East Anglia ONE North Offshore Wind Farm

**Appendix C7 to the Natural England Deadline 5 Submission**

**Natural England's Terrestrial Ecology Update and Comments to Documents [REP3-031, REP4-004, REP4-005, REP4-015 and REP4-043]**

3rd February 2021

East Anglia ONE North and East Anglia TWO
Hundred River and Statutory Designated Sites Location

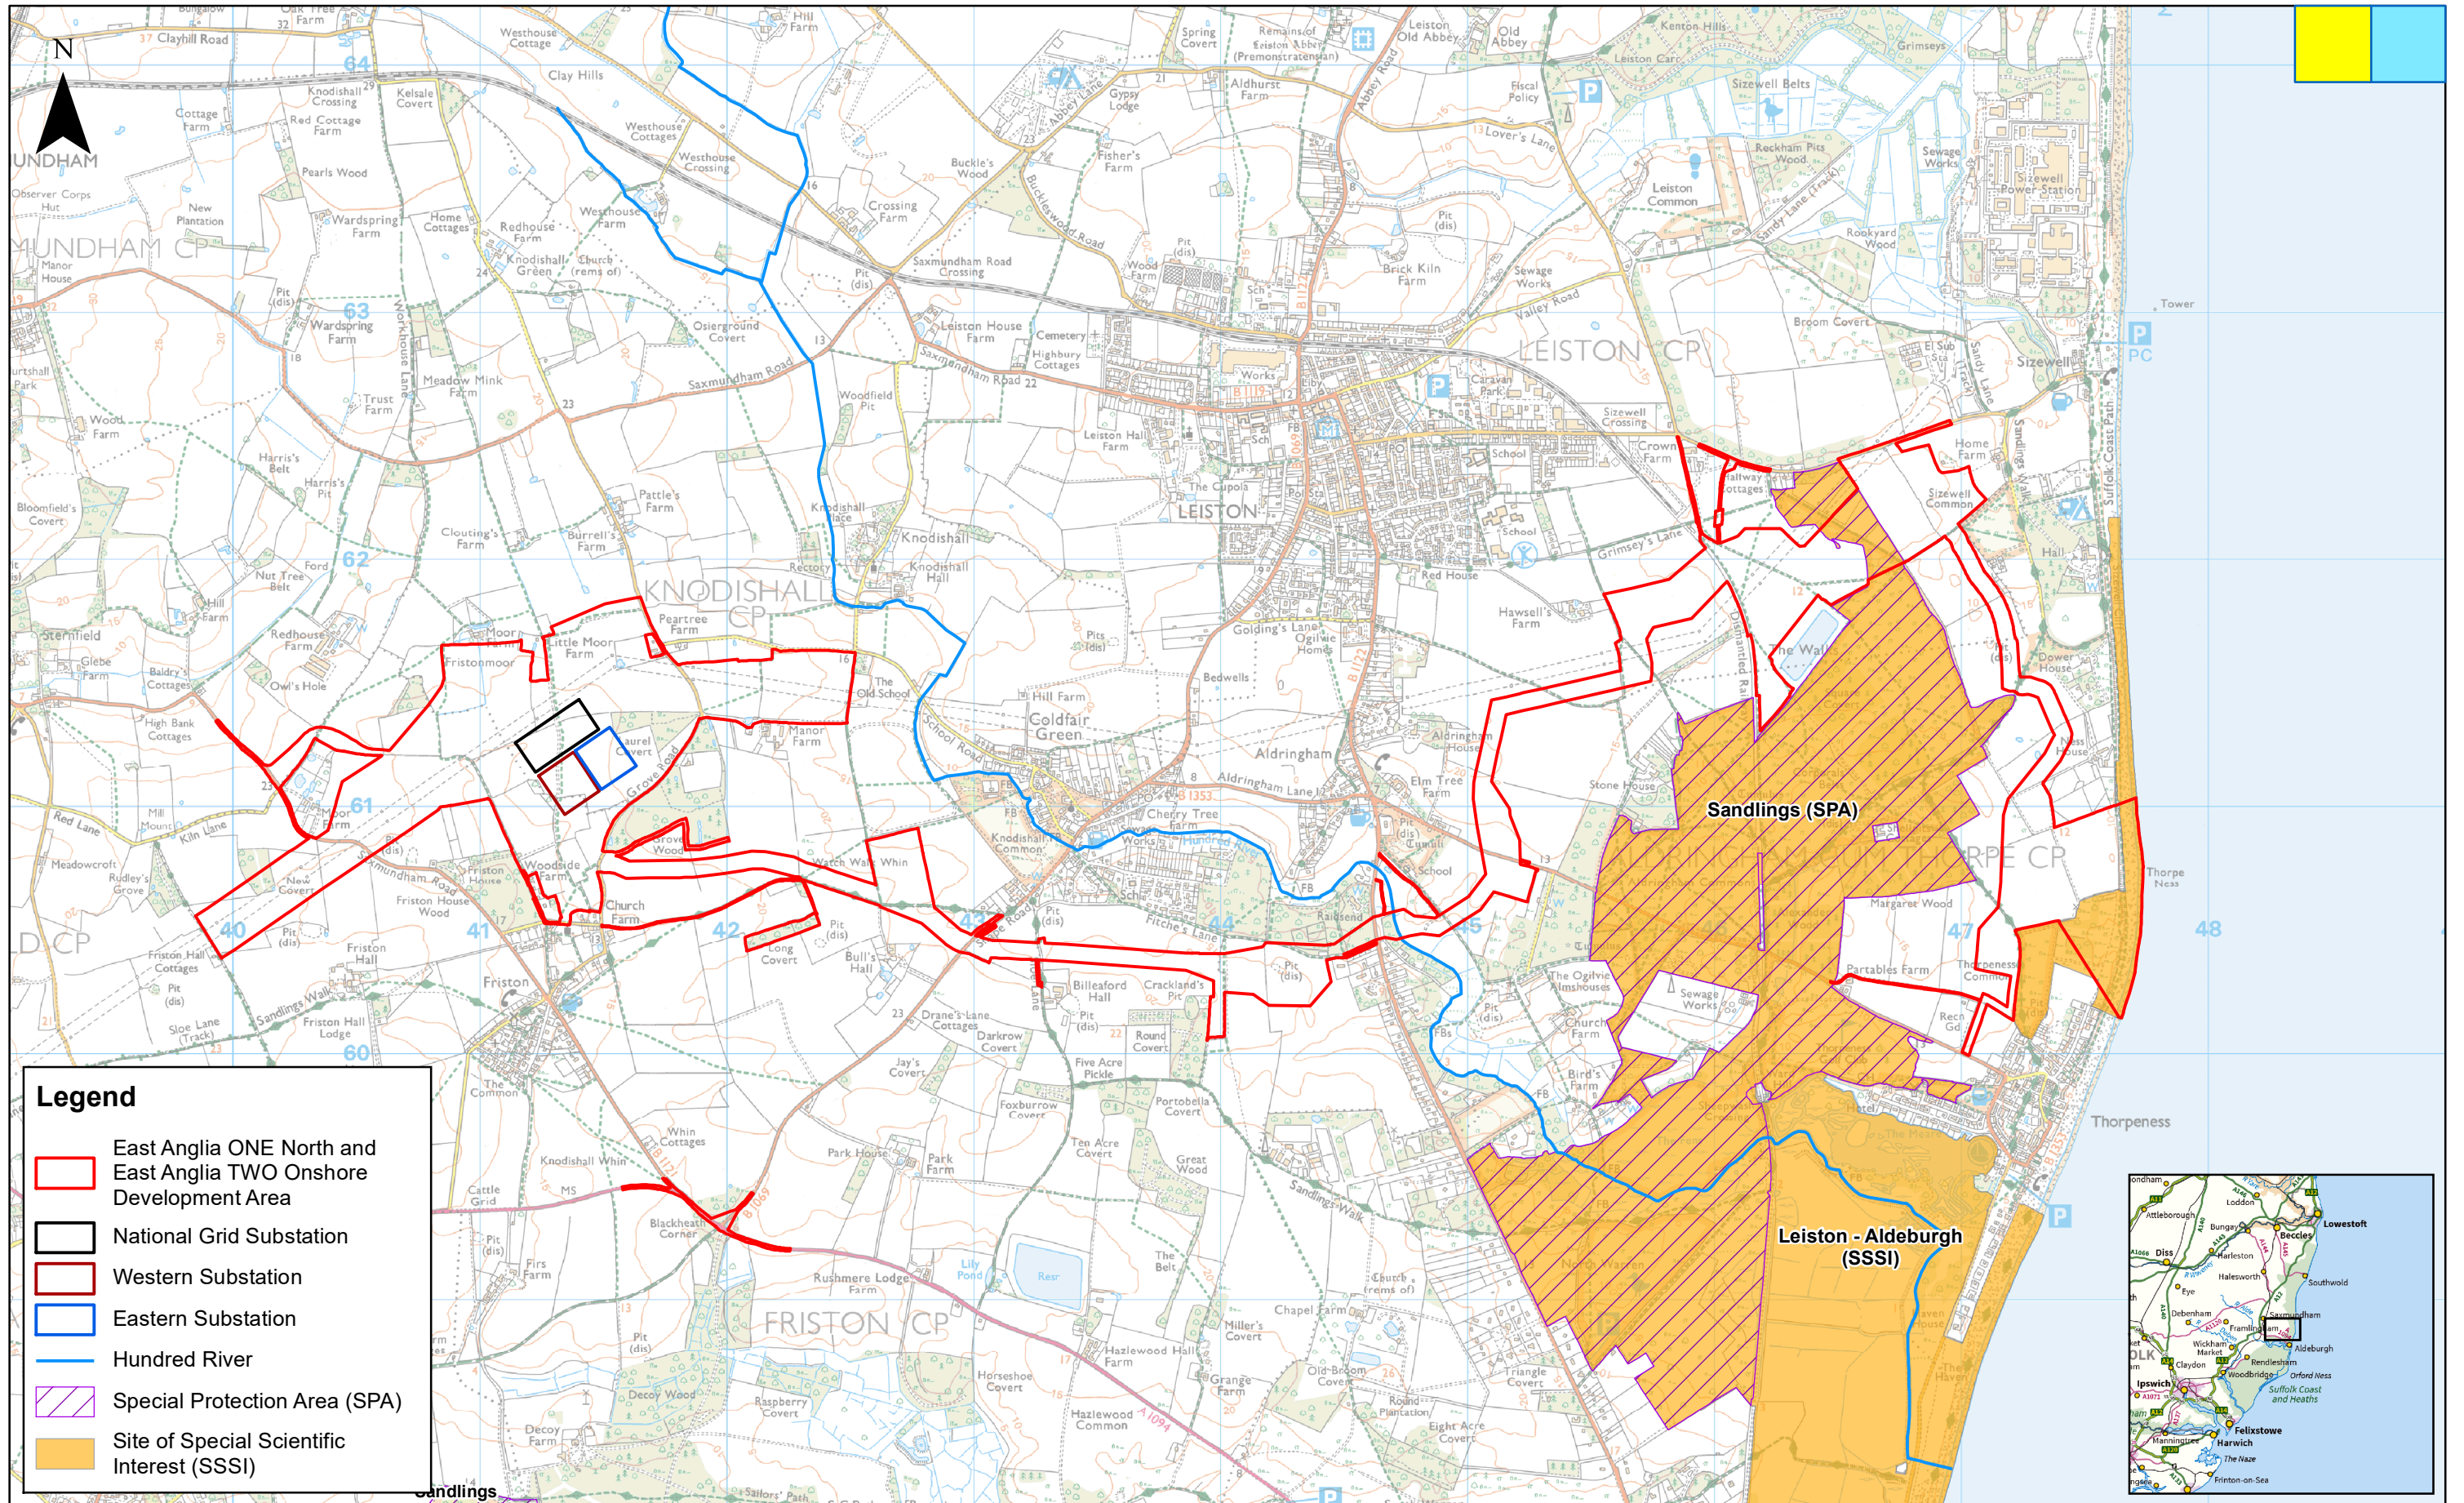
4. During the Issue Specific Hearing 3 on 19th January 2021, Natural England noted that other interested parties raised the issue of potential impacts to wet woodland and non-arable land suitable for the Hairy Dragonfly adjacent to the Hundred River Crossing.
5. Natural England took an action to investigate this further and re-review the survey data presented in the Environmental Statement, which was submitted in Autumn 2019.
6. Please accept this advice in addition to that provided at Deadline 4 [REP4- 092] noting that there is no change in relation to our request for the Applicant to include assessment of impacts to designated sites in any river crossing documentation.

7. Subsequent to the submission of the EA1N and EA2 applications the area of woodland on the west side bank adjacent to the proposed Hundred River crossing location has been identified, in 2020, as Priority deciduous woodland. Unfortunately the mapping software MAGIC.gov.uk doesn't differentiate between the different types of priority deciduous woodland. If this is confirmed as wet woodland, it is a priority habitat under the UK biodiversity Action Plan (UK BAP), which are considered the habitats that are most threatened and requiring conservation. Therefore, Natural England would advise that mitigation measures are required to avoid impacts to this woodland. Please be advised that wet woodlands are sensitive to changes in climate conditions and therefore this woodland is unlikely to recover from the removal of a section of trees, disturbance to soils and changes to hydrological conditions.

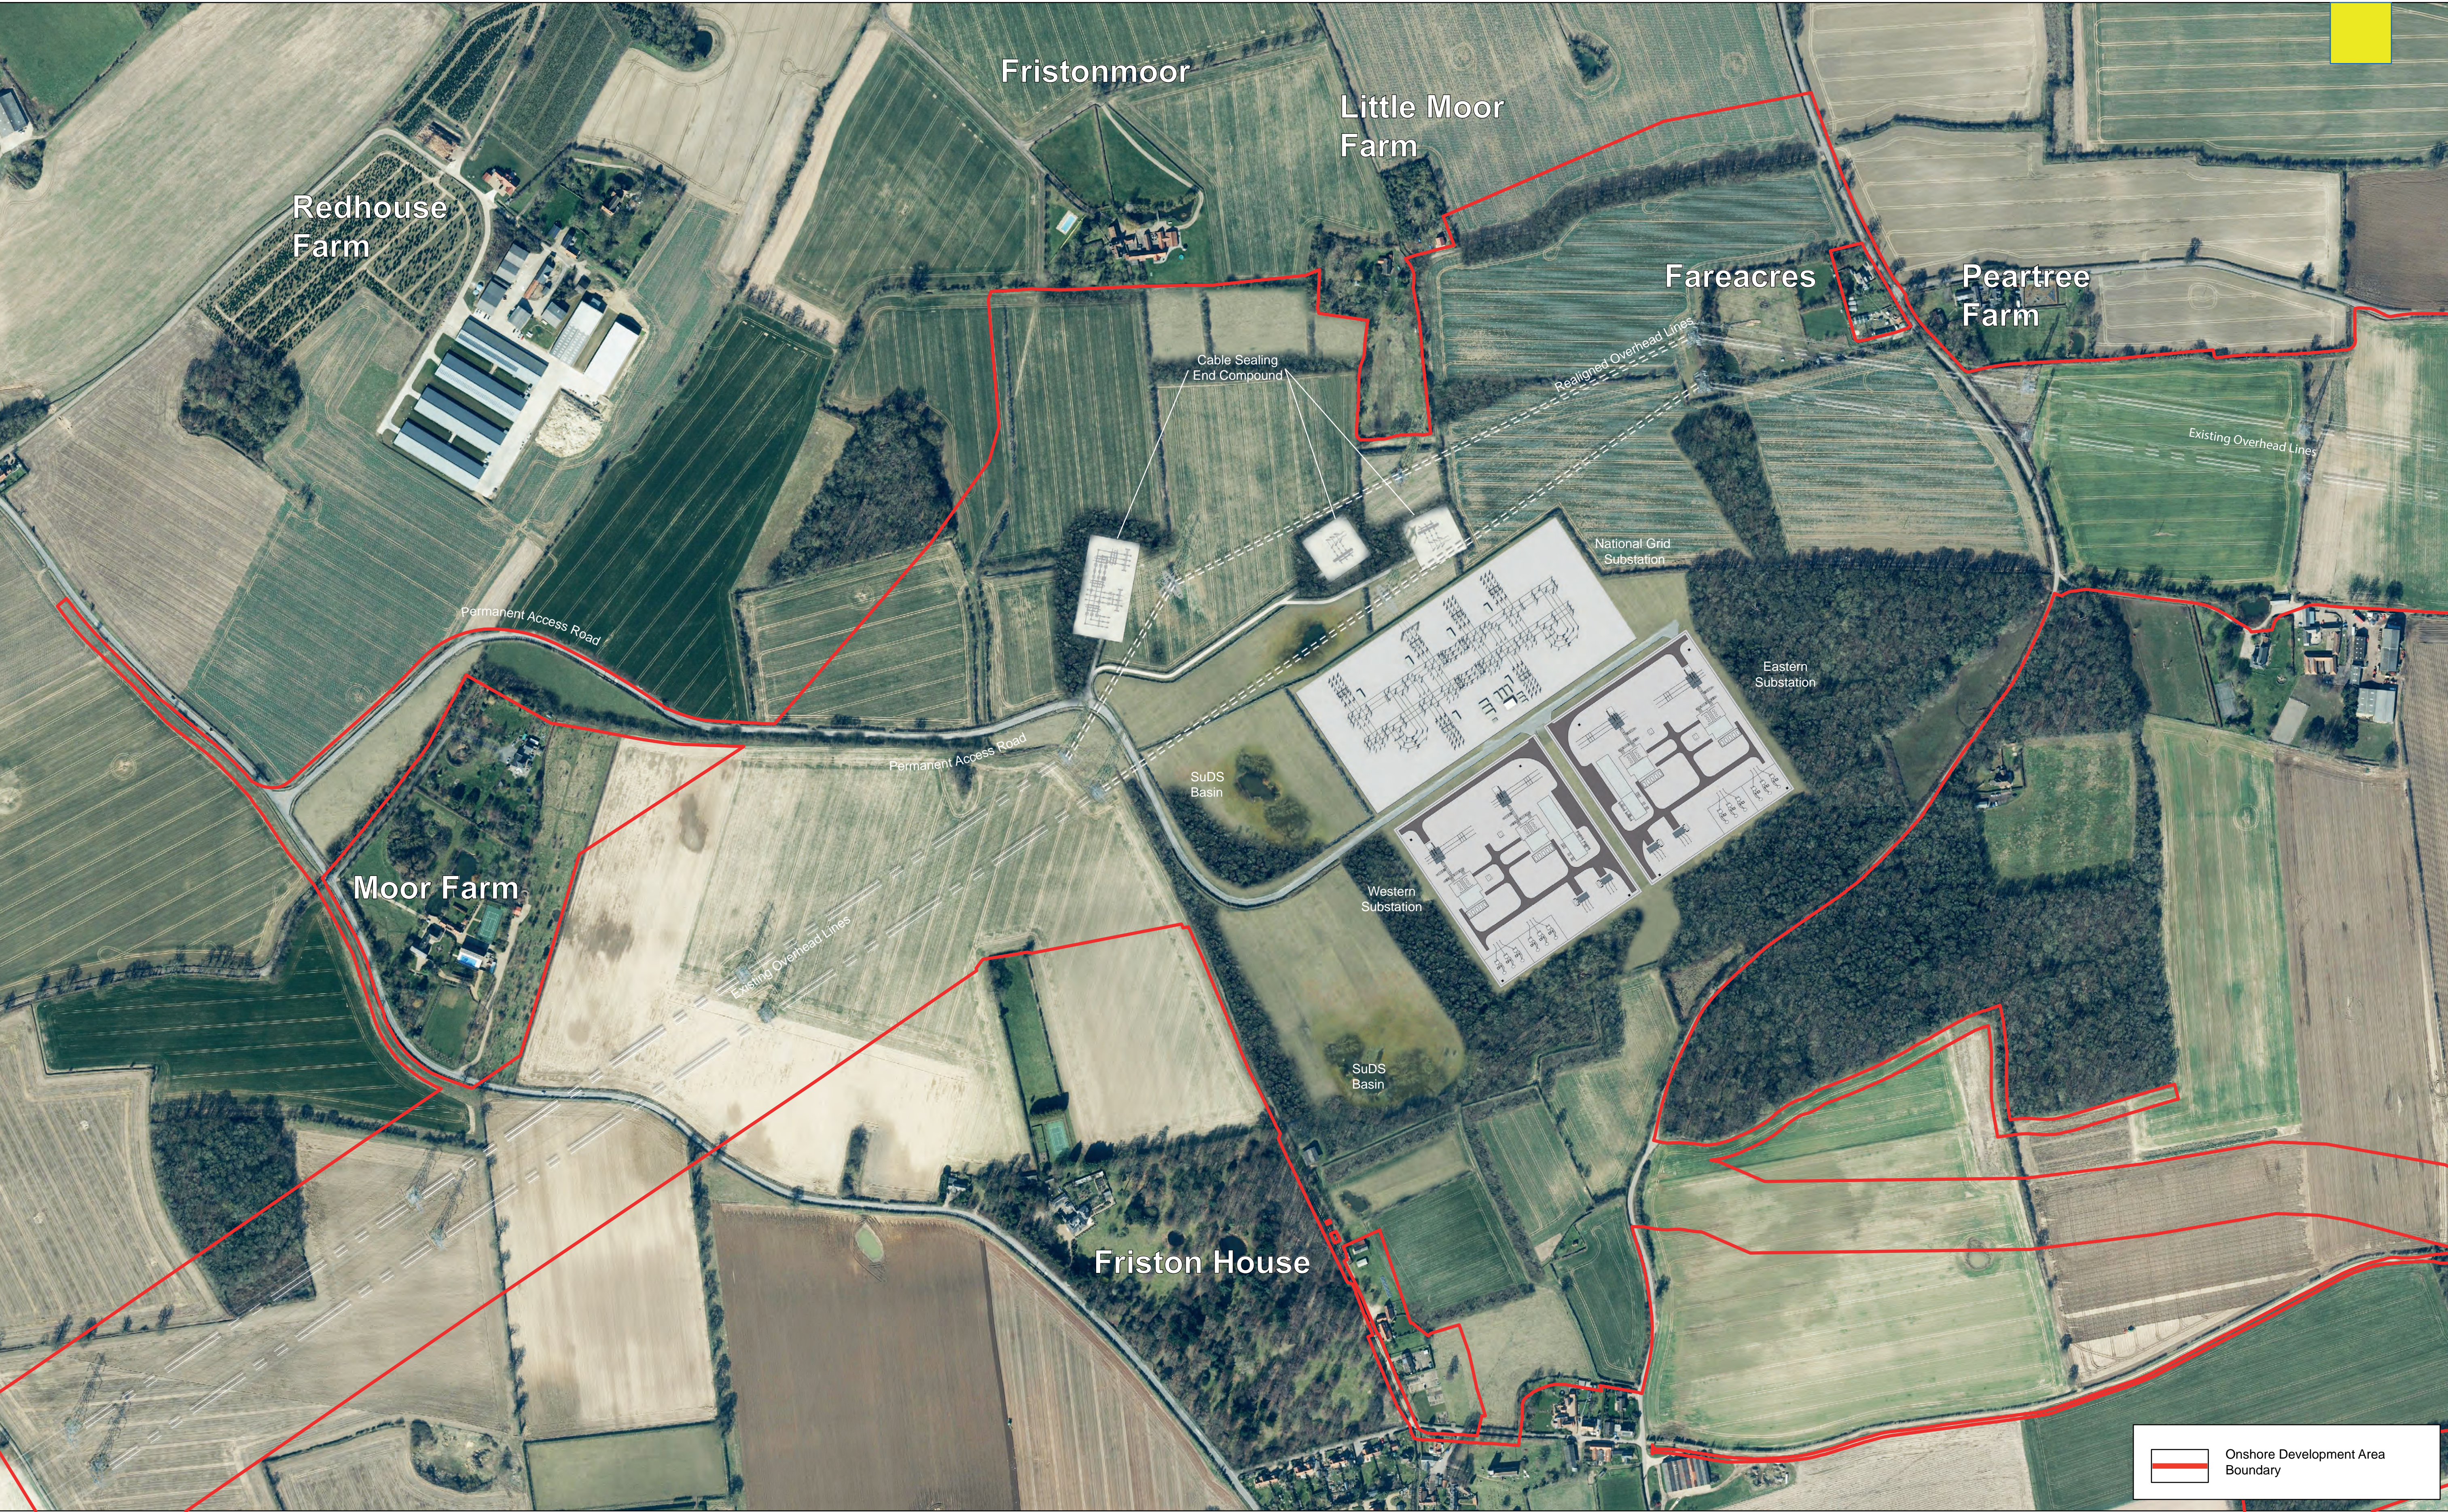
30. Natural England have no specific comments regarding this plan other than to remind the Applicant that the Priority Habitat next to the Hundred River Crossing is likely to need to be included within this plan. See comments regarding the proposed mitigation and enhancement in our comments regarding the OLEMS.
